From: Colin King [REDACTED]
Sent: 28 September 2020 21:28
To: Norfolk Boreas <NorfolkBoreas@planninginspectorate.gov.uk>
Subject: Norfolk Boreas Project EN010087.

REP15-006.

Applicant's Comments on Deadline 15 Submissions.
Regarding the Rochdale Envelope.

Title:	Noise receptor locations
--------	--------------------------

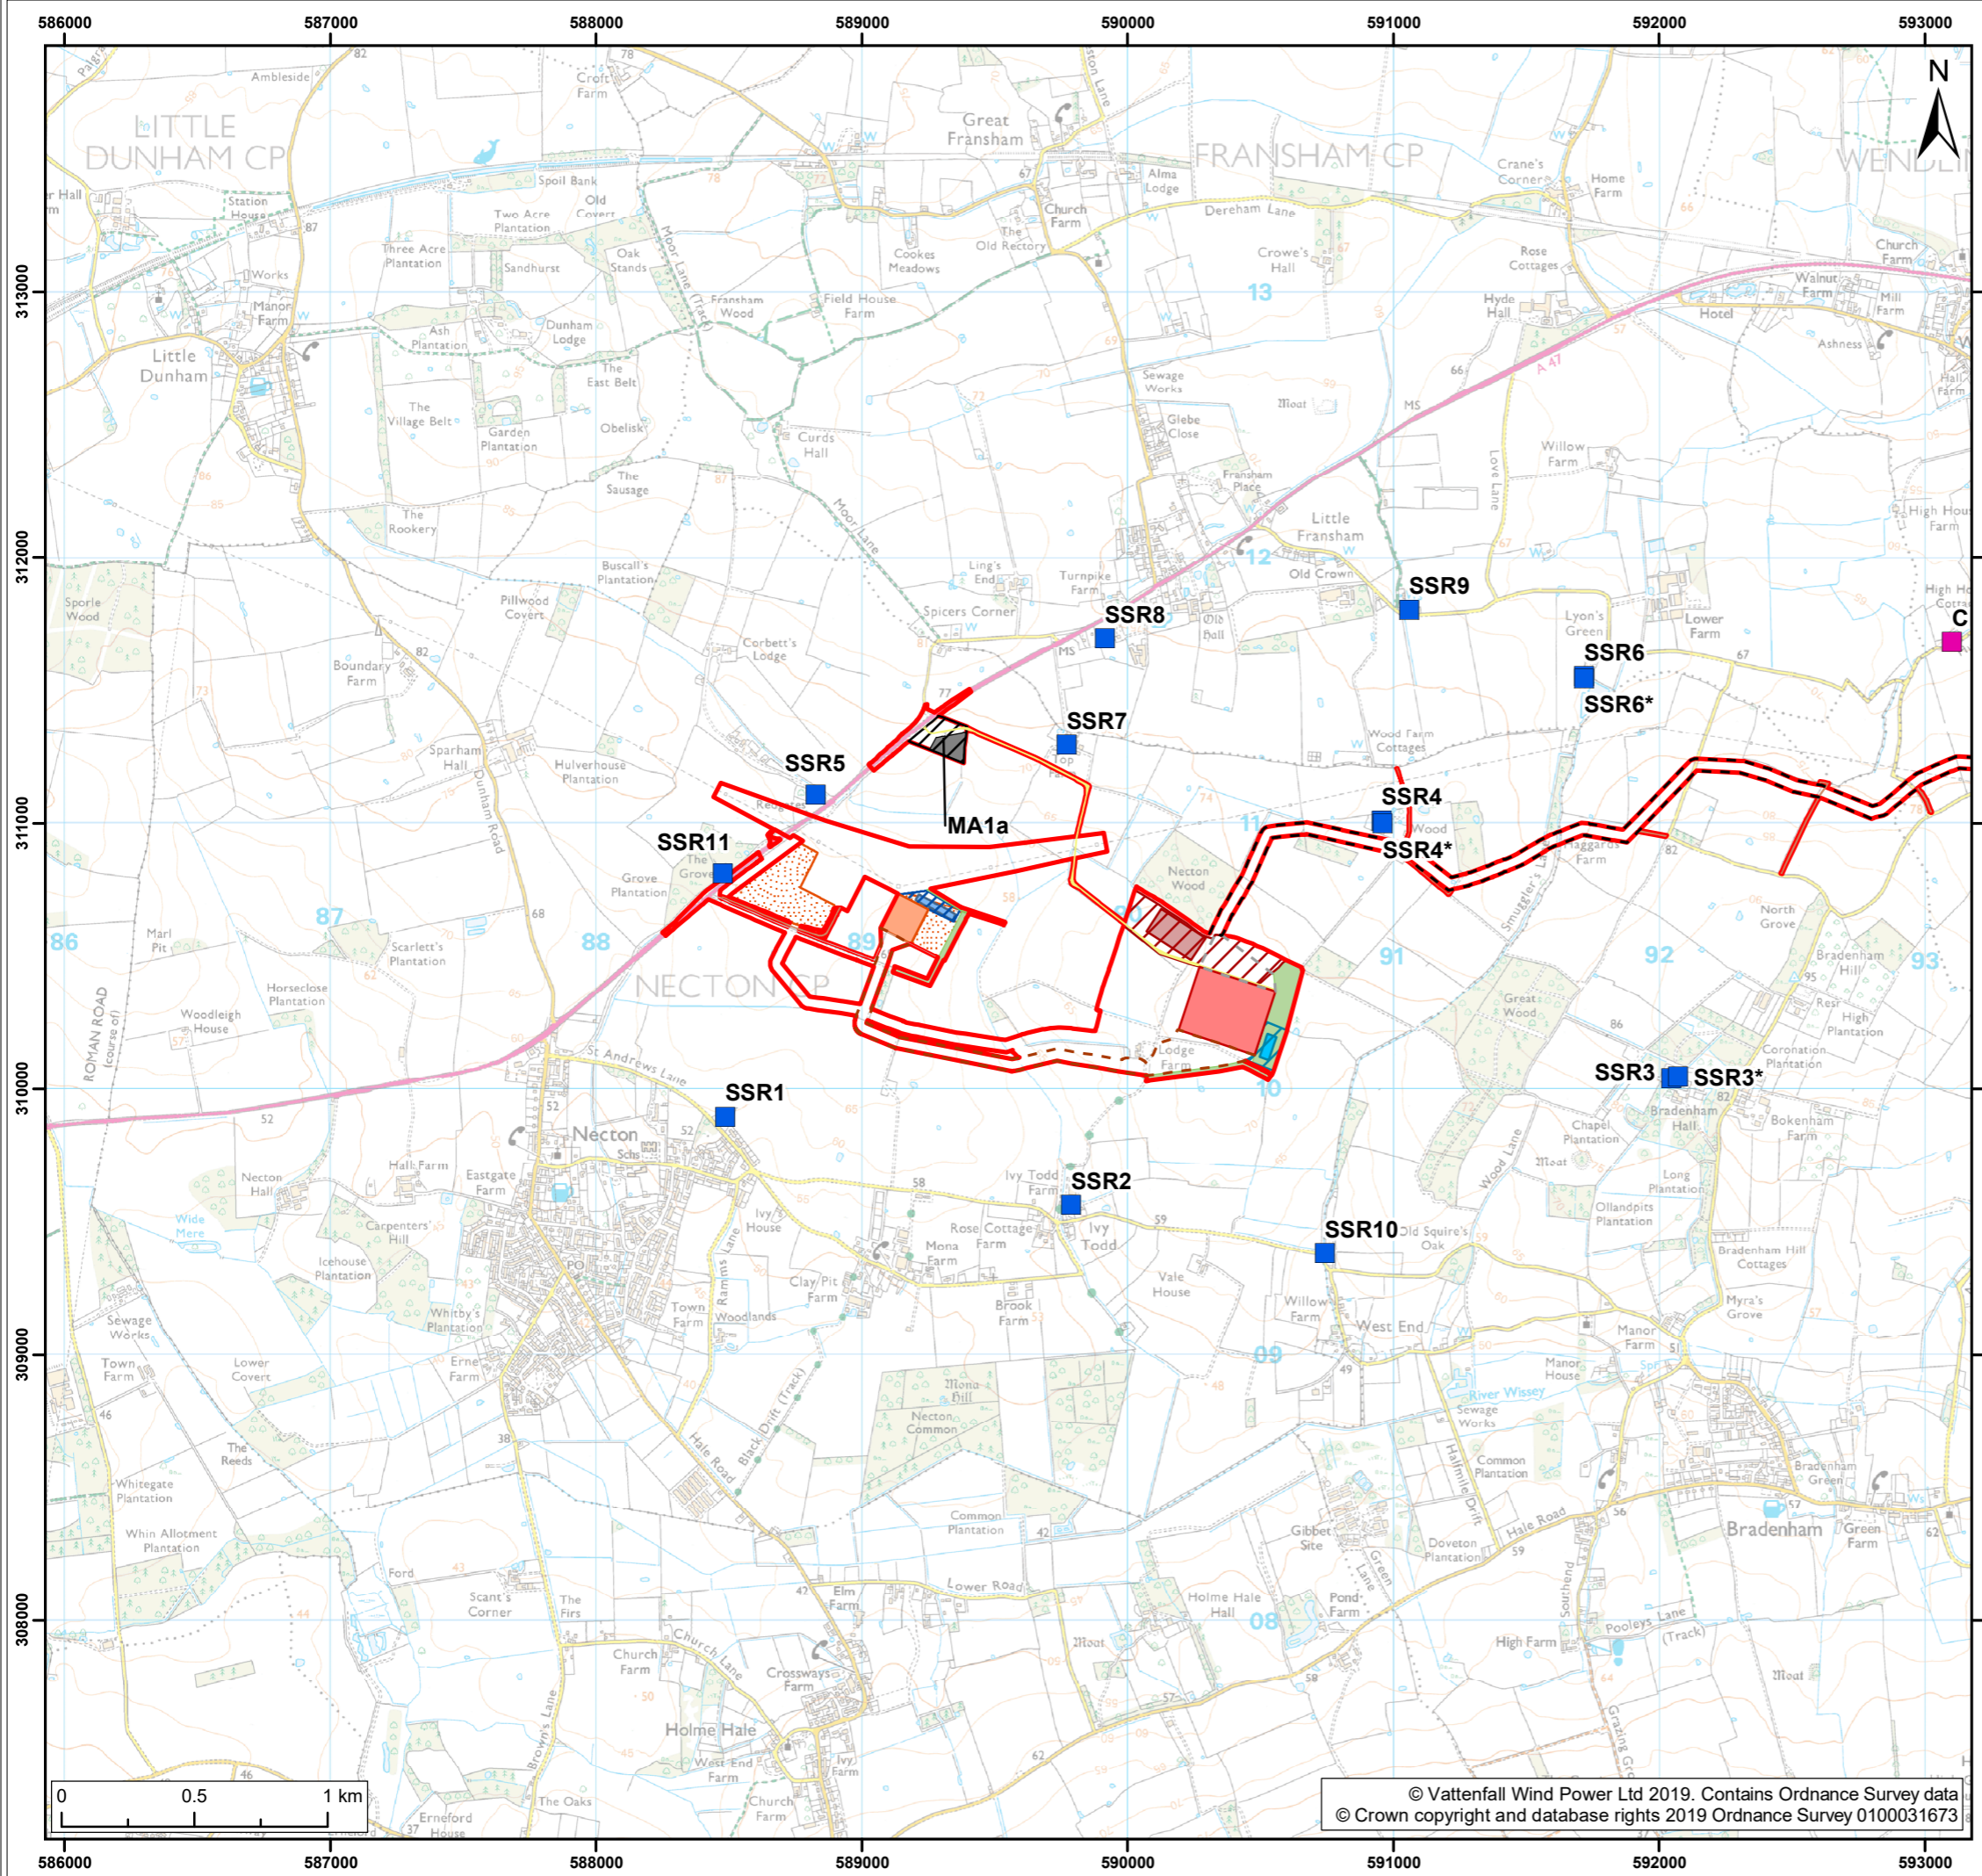
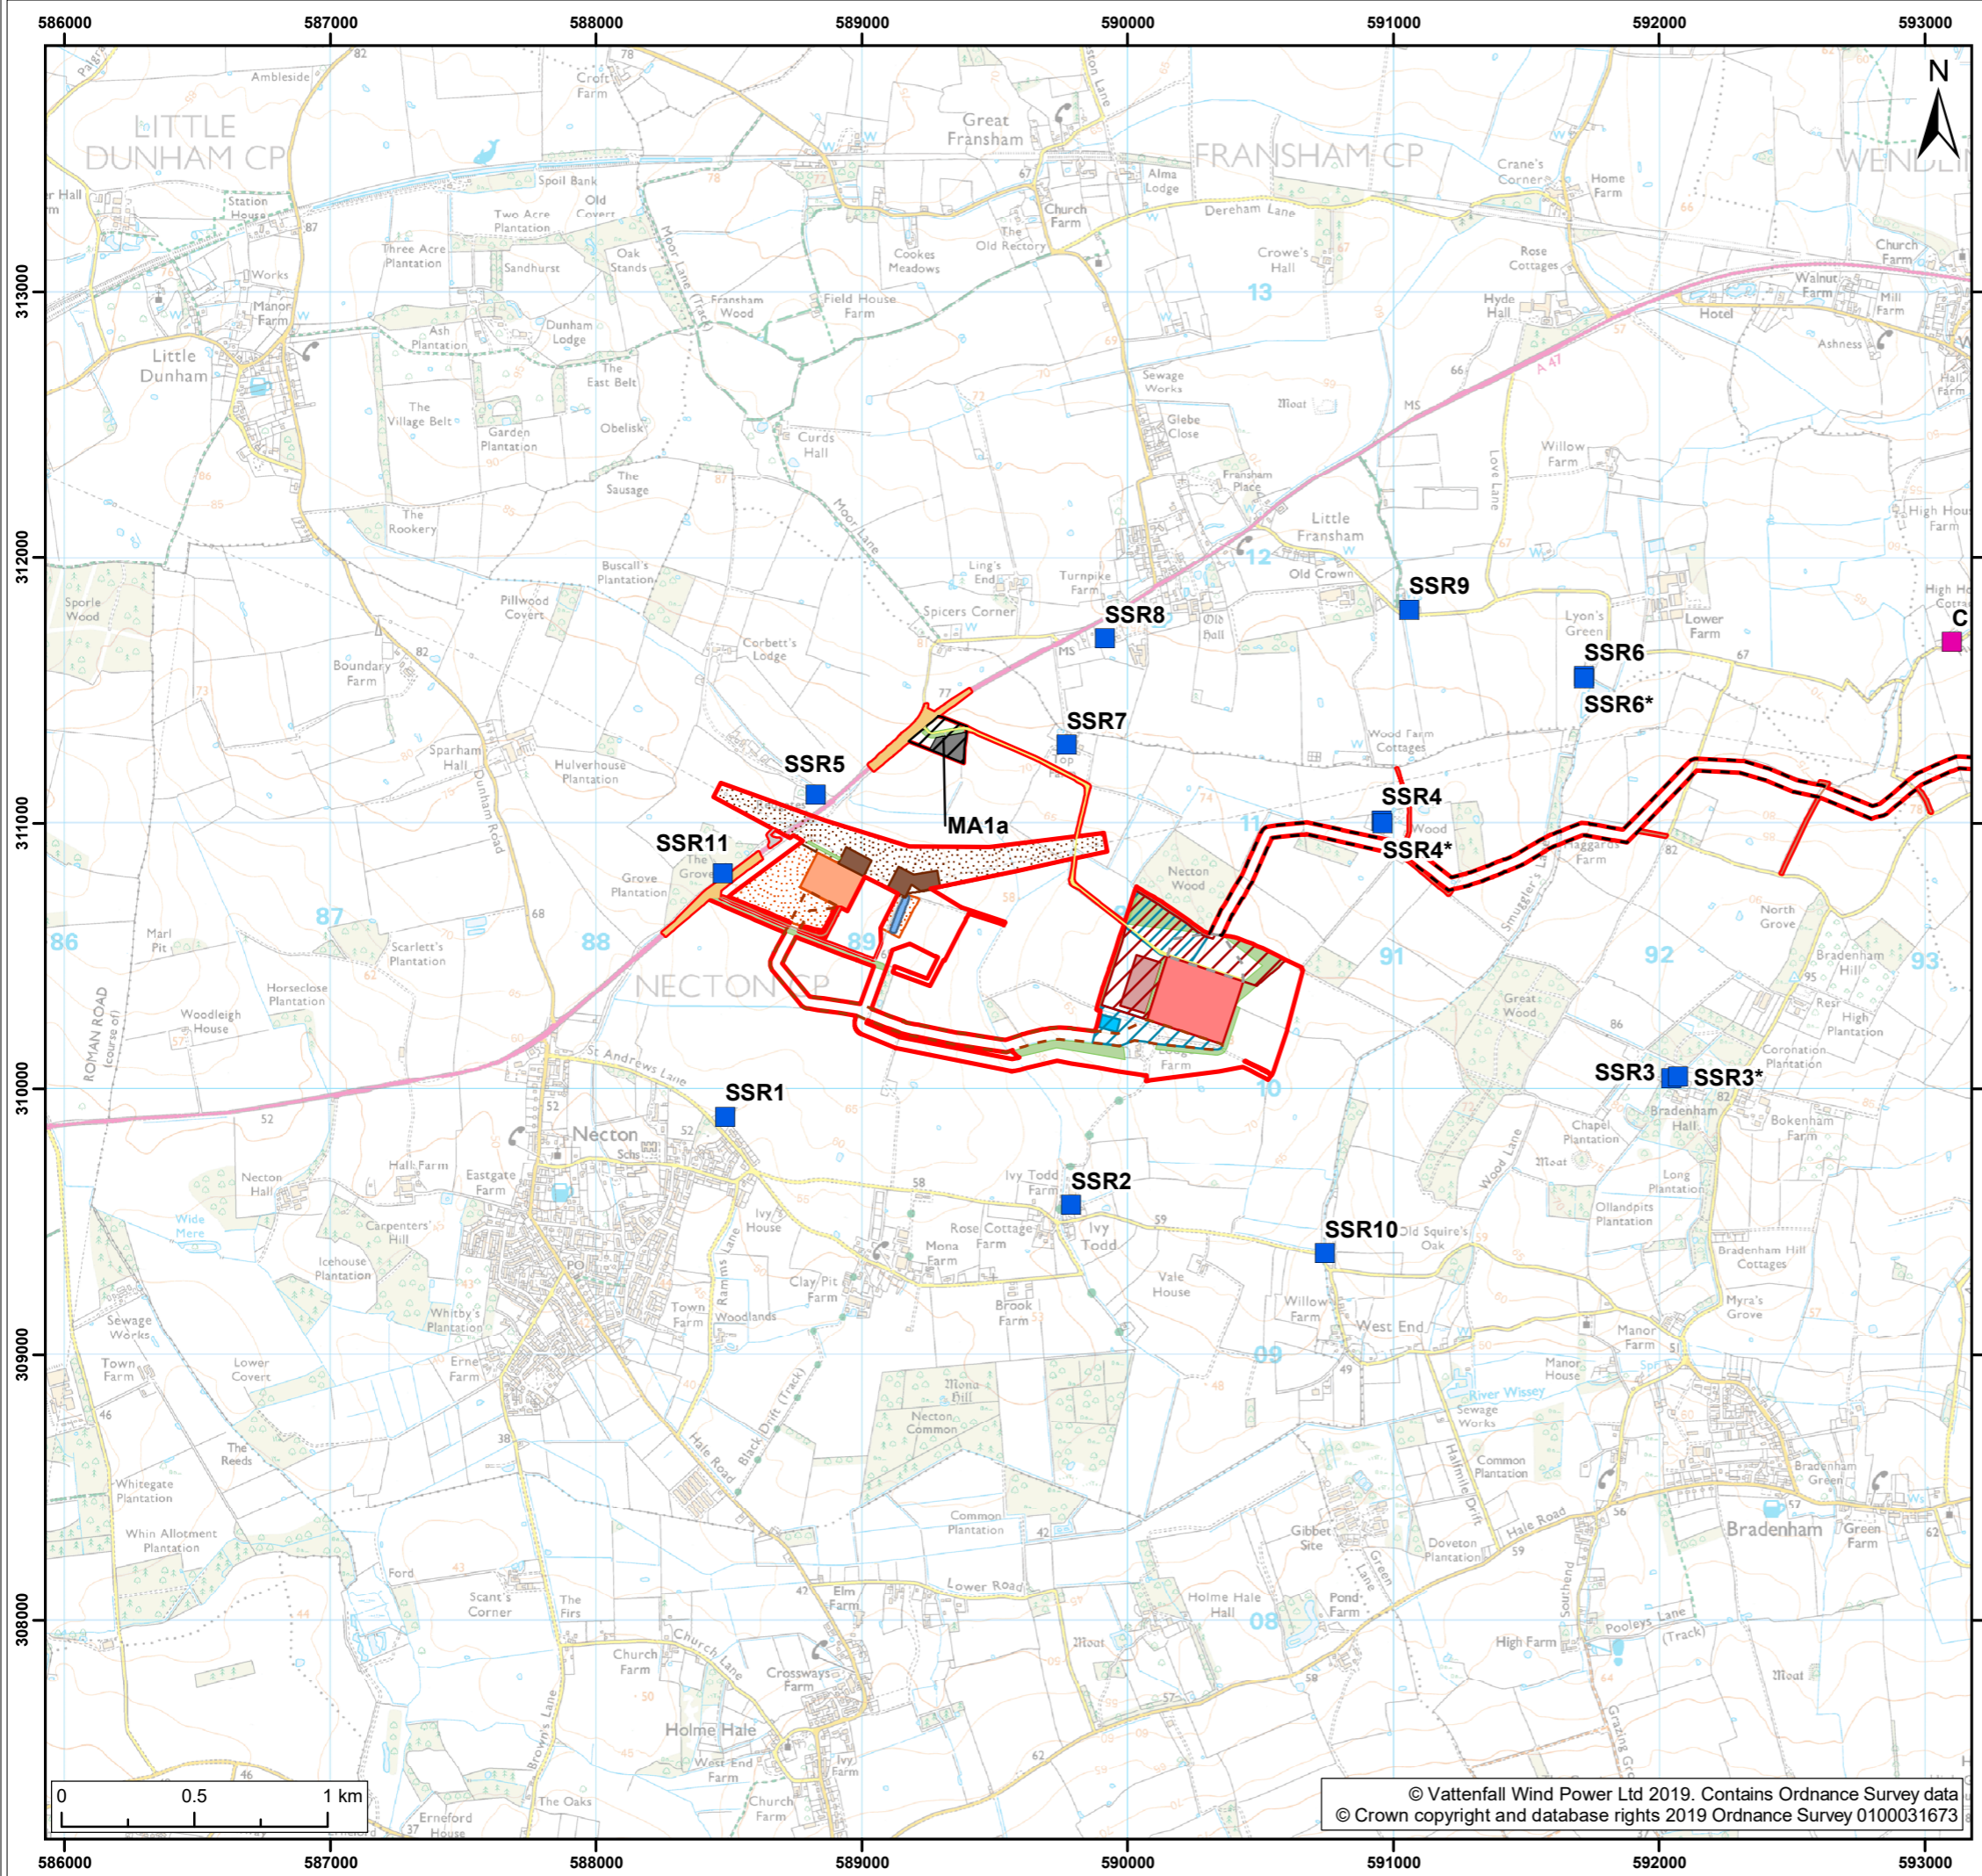
1. This answer still did not answer the question. It did explain, cumulatively with Dudgeon, there will be no increase of permitted noise levels at sensitive receptors. The problem is the permitted noise level at sensitive receptors is the same as Dudgeon's, 35dB 5mins and 32dB 15mins, which was formed from the background noise of its closest sensitive receptor, a property on the A47. While Ivy Todd would be the closest receptor to the Boreas/ Vanguard substation, background noise level, 28.4dB, and at this level the substation noise will be audible over the background noise, except if there were other temporary occupational noises to provide a mask.

The phrase "There is no increase of noise levels permitted at the sensitive receptors," does not mean the noise level being experienced from Dudgeon at the moment will not increase. It means the permitted noise level, which is 35dB/32dB must not be increased. Meaning the noise level currently experienced from Dudgeon, in Ivy Todd is permitted to increase to 6.6dB 5mins / 3.6dB 15mins above the average background level. Totally out of place and unacceptable for a quiet area. Dudgeon's operational noise is undetectable in Ivy Todd.

2. I can not find an answer to my question here. The answer explains that, **"As the proposed footprint of Norfolk Boreas is further from the A47, additional measurement locations were included as part of the Norfolk Boreas onshore project substation survey to determine the prevailing soundscape within the vicinity of the operational site."**

Out of the 12 measurement locations for Boreas/Vanguard, only 2 provided results for the agreed week period. These results demonstrated the closest sensitive receptor had a background noise level 6.6dB 5mins and 3.6dB 15mins below Dudgeon's permitted noise level, and yet Dudgeon's limit was adopted, with no adjustment. Wood Farm is a close property, and as far I am aware is unmonitored, and West End Bradenham being very quiet, should have provided results.

3. This answer states "**Residential receptors were all categorised as being of a medium sensitivity.**" There are properties in Necton close to the A47 and properties in Ivy Todd and West End Bradenham in quietness. This causes differences in sensitivity.
